Ribble Valley Borough Council
Housing & Development Control

Application no: **3/2021/1092**

Address: **Brockthorn Laithe Wigglesworth Road Slaidburn BD23 4SX**

Proposal: **Construction of three holiday lodges with associated parking, access and landscaping.**

Proposed Site Layout
 Scale@1:200

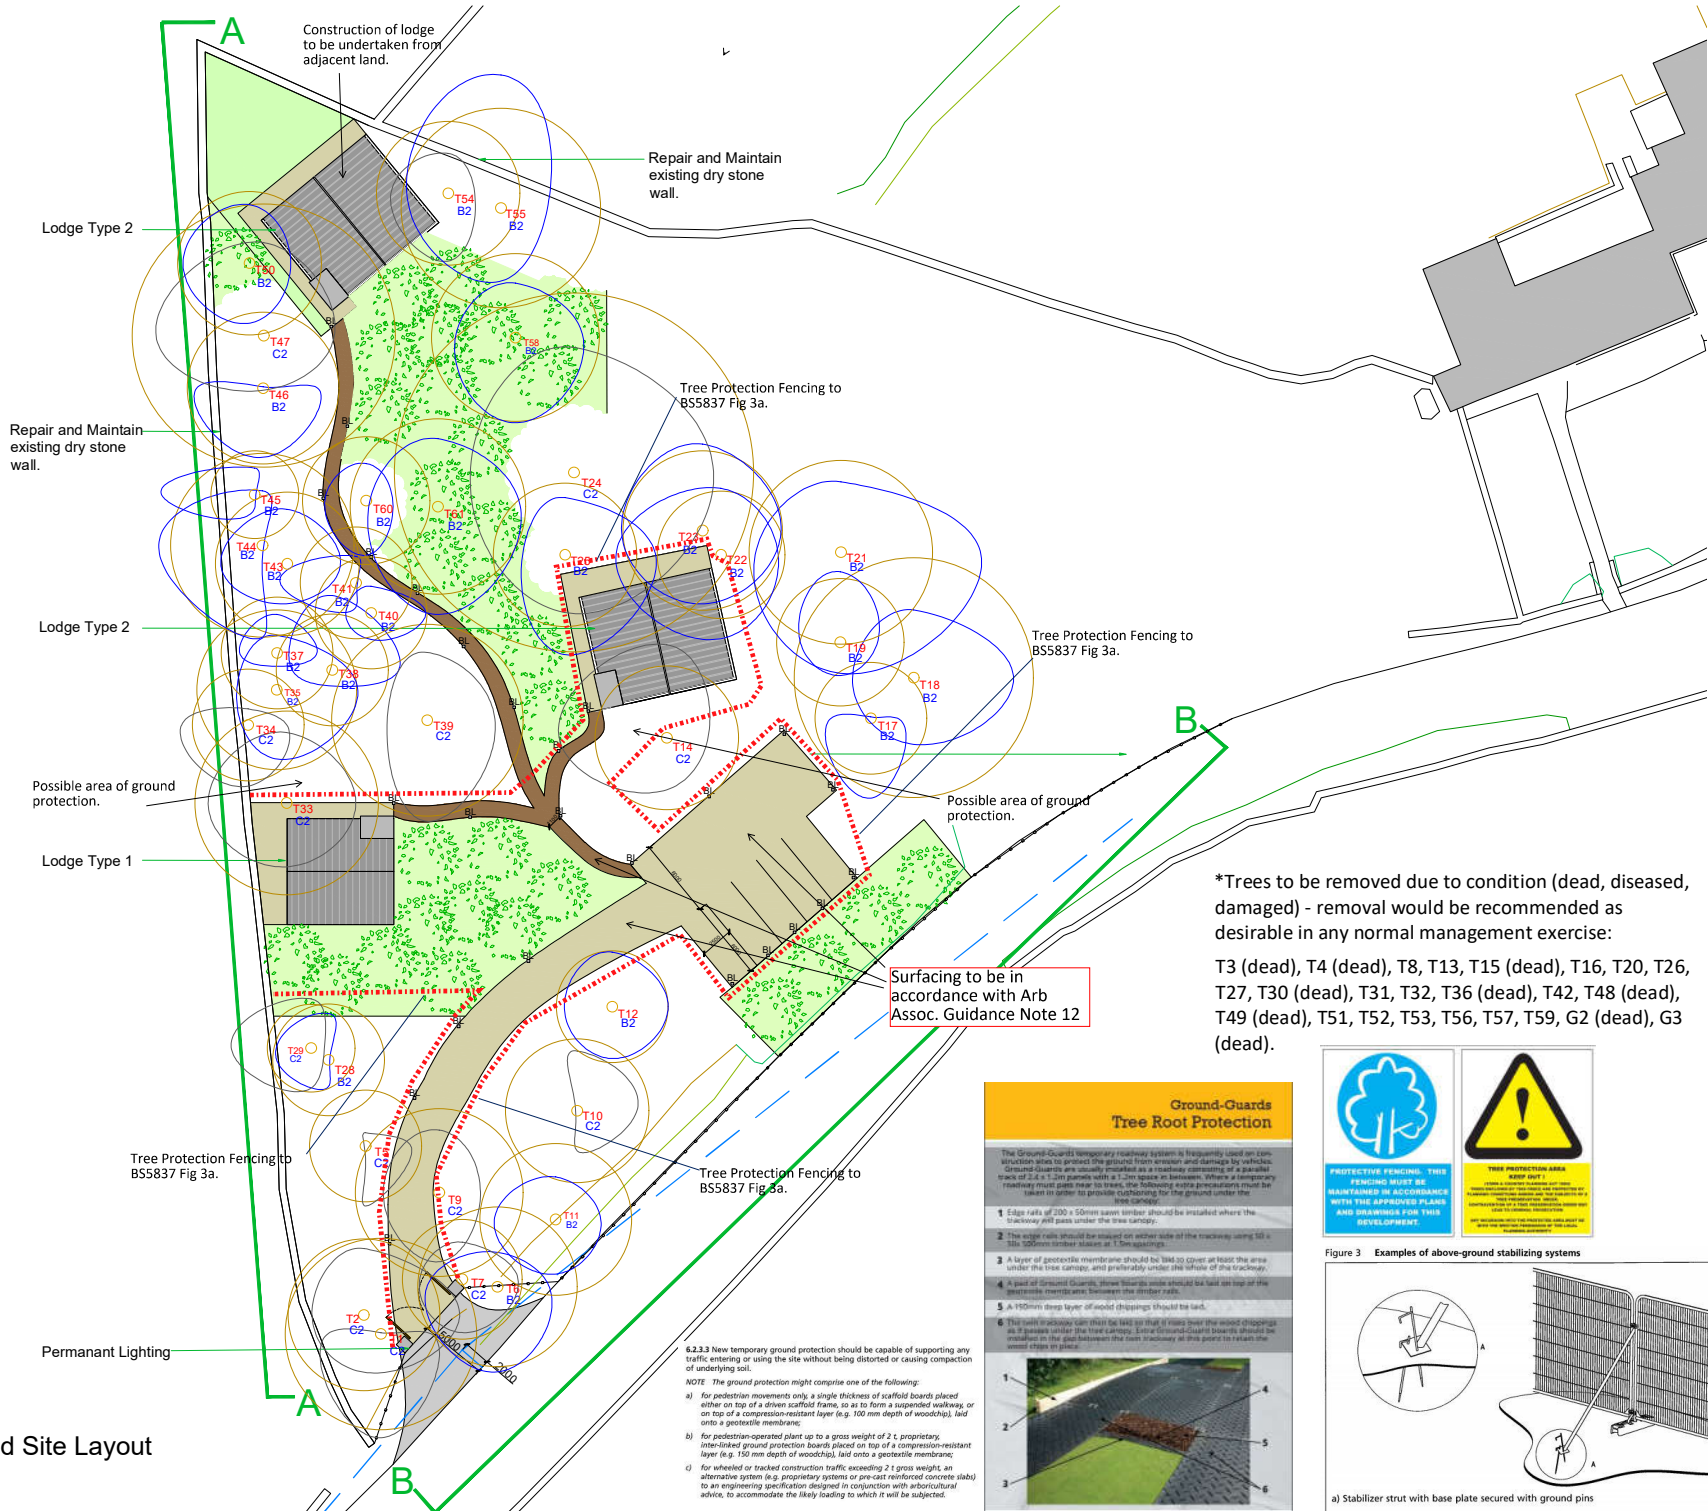
The LHA are aware, by reviewing SPA drawing number 6284-P02 titled "Proposed Site Plan," that the existing access will be improved following the proposal.

The LHA have reviewed the drawing and are satisfied that the access arrangements complies with the LHAs guidance and so the LHA have no further comments to make.

However, the LHA have noted that the site access is unable to provide the minimum vehicular visibility for a 60mph road. This is because as shown on SPA drawing number 6284-P02 titled "Proposed Site Plan," the site can only provide visibility splays of 2m x 65m to the left and 2m x 75m to the right of the access.

The LHA normally require for a 60mph road, visibility splays of 2m x 214m in both directions. Therefore, there is a shortfall in visibility of 149m to the left and 139m to the right.

For the LHA to support the shortfall in visibility at the site access, the LHA require a speed survey to be undertaken in the vicinity of the site. The speed survey which can be undertaken by a private traffic survey company will record vehicle volumes and speeds and will demonstrate 85th percentile speeds which can be used to support the sites visibility splays.

The LHA have reviewed SPA drawing number 6284-P02 titled "Proposed Site Plan," and understands that the site will provide 5 car parking spaces for the 2 x 2 bed and 1 x 1 bed holiday lodges. This complies with the parking guidance found in the Joint Lancashire Structure Plan and so the LHA have no further comments to make.
